Your ref: 3/2012/0724
Our ref: DC/12/3945
Date: 15-OCT-12

Location: 47, Knowsley Road West Clayton Le Dale, Blackburn
Proposal: Erection of 1 dwelling

Site Plan 1:500

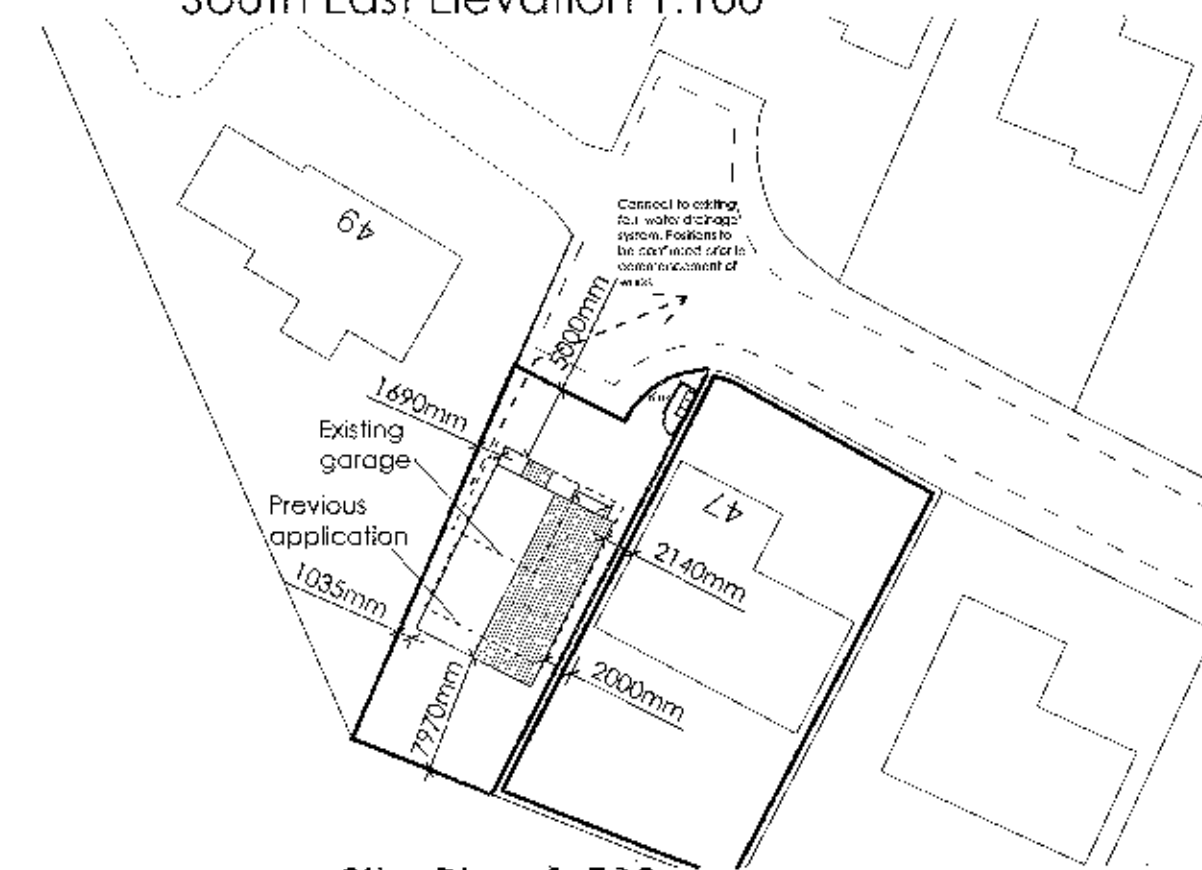
With reference to the above planning application, the development is in close proximity to a strategic large diameter trunk main supplying water to many thousands of customers in the Blackburn area. The main is protected by a 10m easement width therefore provided no part of the proposed structure is within 5m of the centre line of our main, we have no objection to the development.

The need for this 10 m easement was identified on the previously submitted application reference 3/2009/0542. United Utilities advises the applicant that it is necessary to confirm the exact location of the main and these details should be provided to our planning liaison team. Once the location of the main is confirmed, it may be necessary to amend the location of the proposal.

'Prior to the commencement of development, a scheme, hereinafter called the Water Main Approved Method Statement, for working near the water main shall be submitted to and approved in writing by the Local Planning Authority. The scheme shall include the provision of a 10 m easement centred over the large diameter trunk main. No development or other operations shall take place except in complete accordance with the Water Main Approved Method Statement, unless otherwise agreed in writing with the Local Planning Authority.'
